Westfield House,
Fontwell Avenue,
Eastergate,
West Sussex.
PO203RU
2.8.17

We wish to object to planning application AL/72/17/PL for the reasons listed below:-

TITLE
PROPOSED SITE PLAN
PLOTS 1 & 2

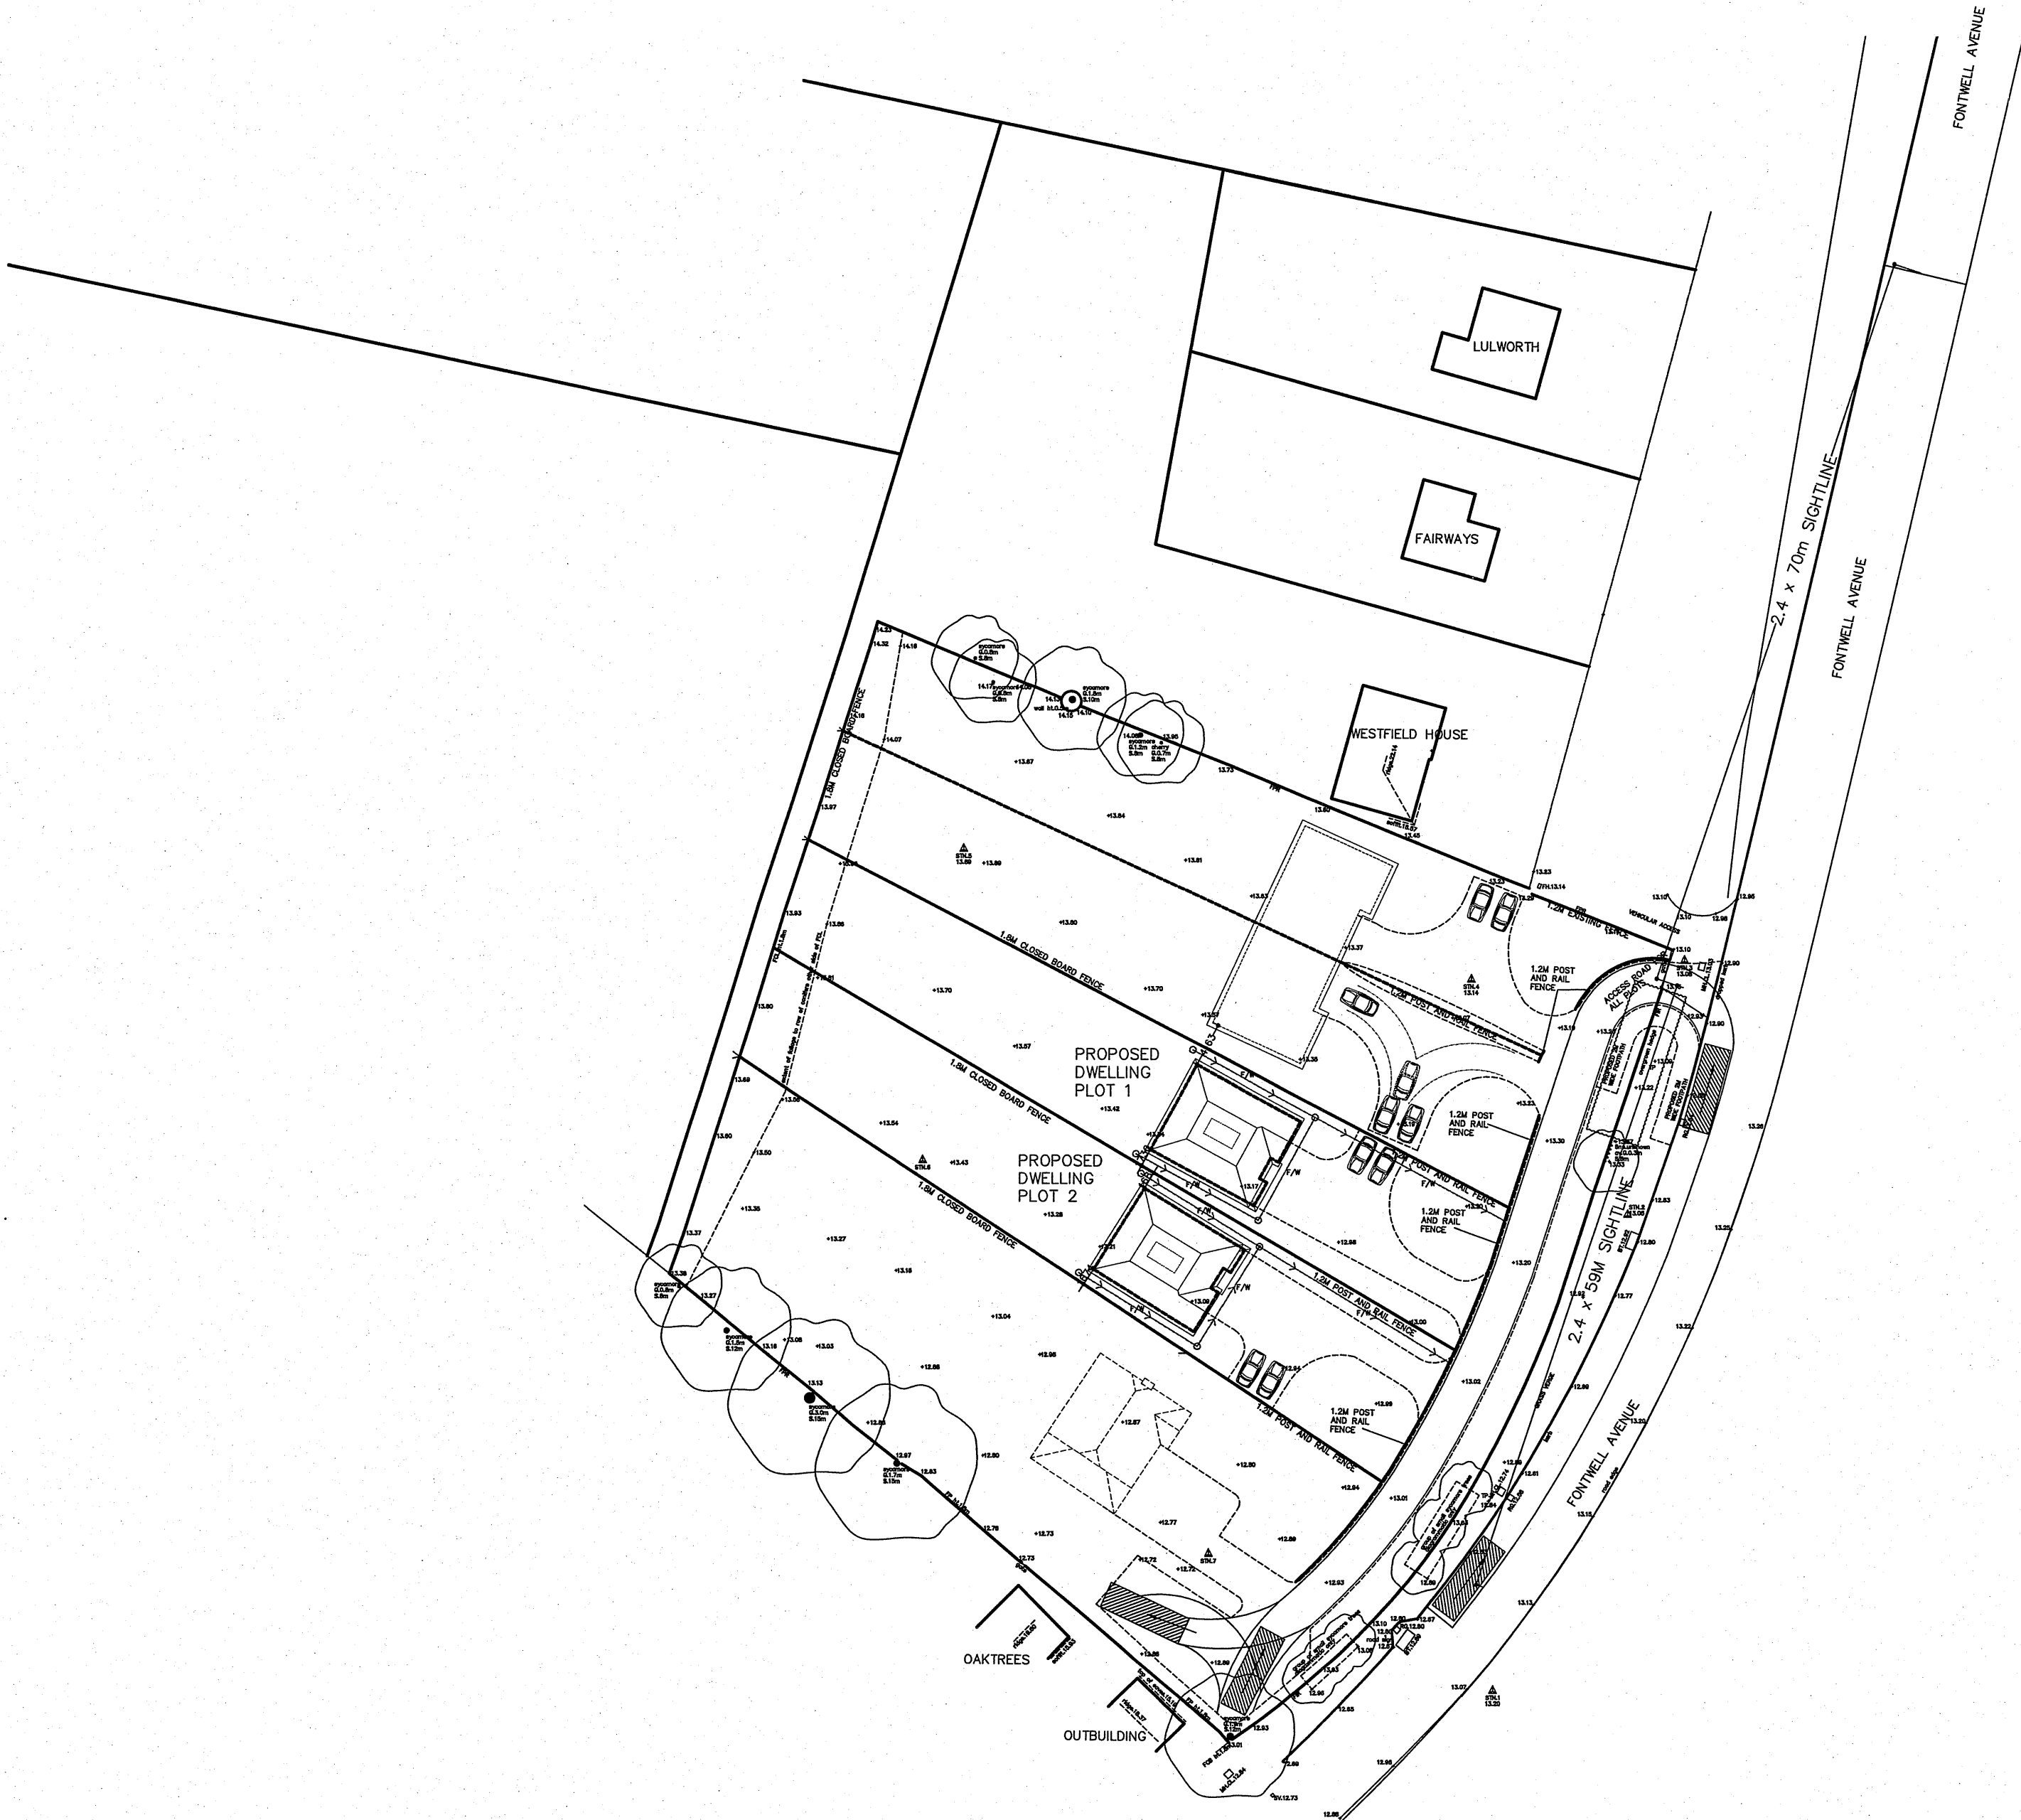
4. Application AL/121/16/PL was itself based on application AL/95/13/14 which gave outline planning for 3 detached houses with garages. The removal of garages from future applications (including this one) has adverse implications for parking and road safety. It is also out of character with the other properties found on Fontwell Avenue which all have garages or at least rear access.

5. The occupant of plot 1 (AL/121/16/PL) currently keeps 4 cars on site. The approval given under this application only allows for 2 parking spaces for each unit. An increase in the number of units granted planning

permission, means a greater number of cars needing space to park. The units already agreed and those proposed, have no garages and no rear access. Therefore, any extra cars will need to park in the access road. It will become a car park and unless made dual-width, will restricted free access to ambulances, fire engines and the like.

6. The Design and Access Statement for the proposed development says that the gaps between the houses will be similar to others in the Avenue. This is not so. The layout of this proposed application is the same as Planning Application AL/106/15/OUT, which was rejected and then appealed, and finally dismissed by the Planning Inspectorate, for this very reason. The proposal was for 5 detached houses with garaging across the whole of the field. The Appeal Inspector, Mr. Andrew Steen BA (Hons) Dip TR MRTPI, gave reasons for his refusal and I quote,

It should be noted that Application AL/72/17/PL proposes 2 detached houses in the same position and with the same gaps, as those on plots 3 and 4 in the application referred to and rejected by Mr. Andrew Steen.
